**Unanderra Liquid Waste Treatment Facility (SSD-8304)  
Request for additional information**

I refer to Response to Submissions for the Unanderra Liquid Waste Treatment Facility (SSD-8304).

Figure 3: Predicted annual average Pb concentrations ($\mu\text{g}/\text{m}^3$)

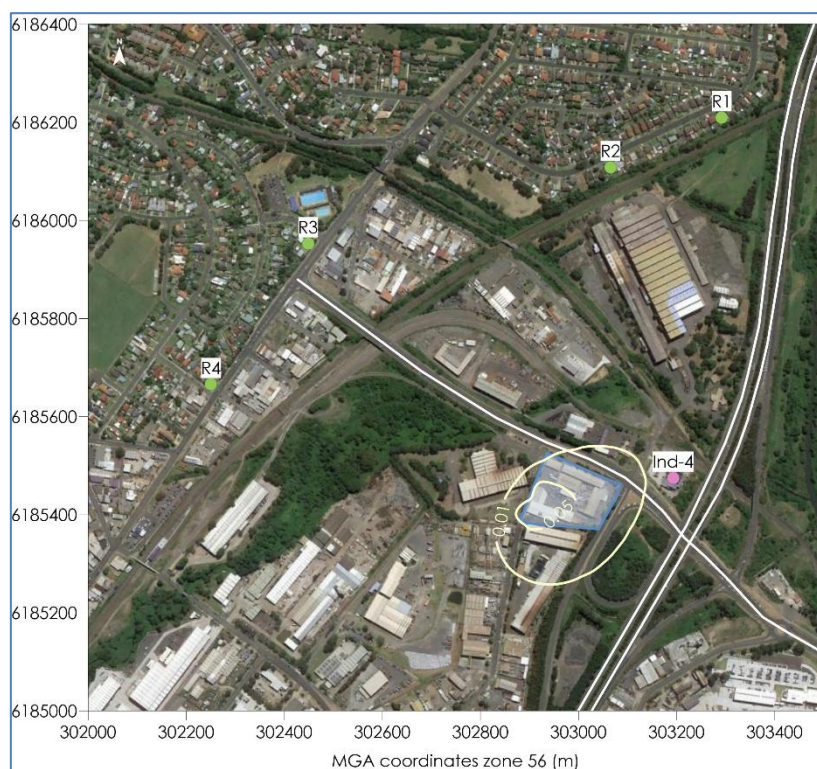
- The updated air quality modelling in the Todoroski Air Sciences letter (dated 15 December 2021) provides updated predictions of a range of pollutants, including lead. Please provide an assessment of the cumulative impacts of lead (Pb) emissions based on the updated emission rates in the revised AQIA or justify why a cumulative impact assessment has not been carried out.
